From: Mark ABMH [REDACTED]
Sent: 19 December 2017 12:29
To: Paul Cann; 'Kevin Macknay'
Cc: 'ben smith'; 'Luke Davies'
Subject: RE: M/121/17/DOC - Former Post Office, 155 Middleton Road, Middleton On Sea, W Sussex, PO22 6DF
Importance: High

## 450x450 Catchpit Chamber with RG Grating

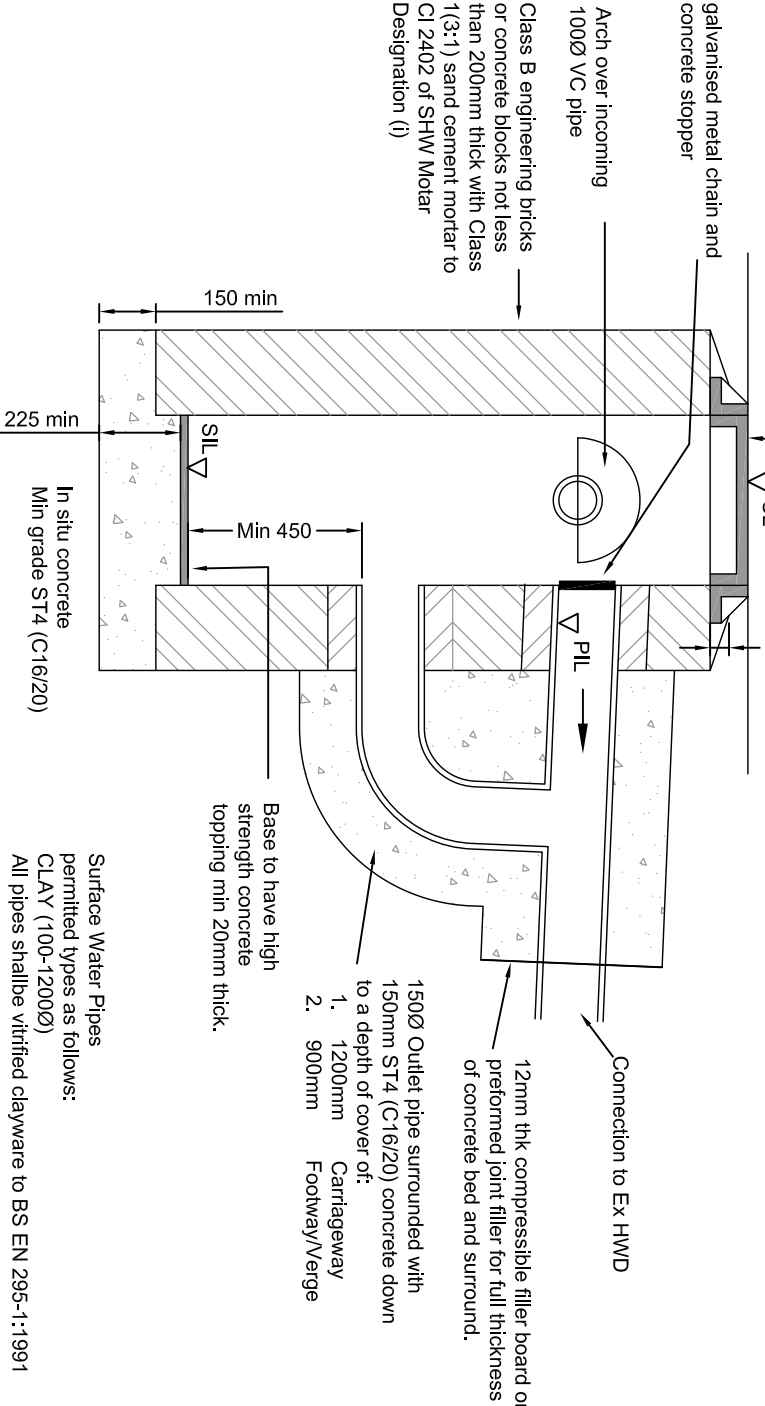
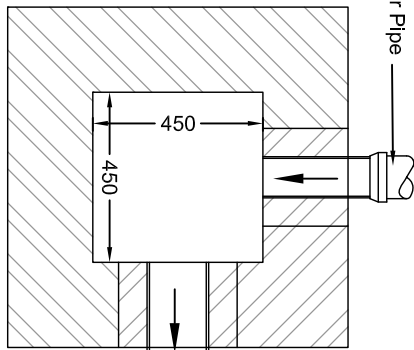
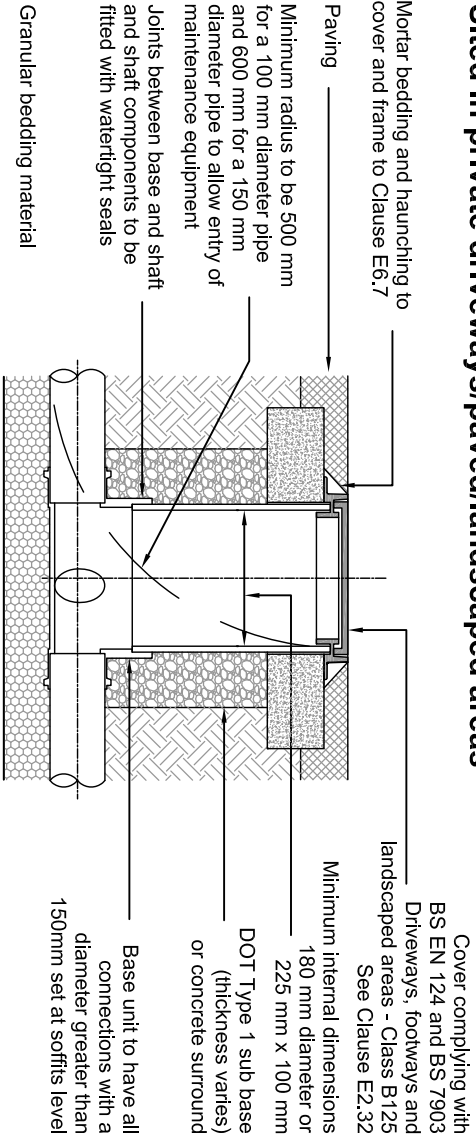
1. Orifice flow control chamber
 - a. This is basically a 450mm dia catchpit with 1no 100 pipe entering from the formpave fin drain and two No 100 mm diameter connections from this chamber to the existing HWD RG connections within the site.
 - b. The flows are effectively controlled by the incoming 100mm pipe into this chamber – ref SW1C on the attached drawing 02F
 - c. Max flow 8.5l/s based on nothing going into the soil and during a 100yr SRP + 30%
2. Formpave outlet arrangement is via a fin drain to the orifice IC
 - a. Fin drain detail outlet from Formpave will be available tomorrow from Formpave – I'll forward asap
 - b. Updated Formpave dwgs also to be forwarded
3. Ex RG alteration
 - a. Proposed 450x450 brick chamber with gully type trap and grating
 - i. See attached details – dwg 05
 - ii. Kevin – this OK
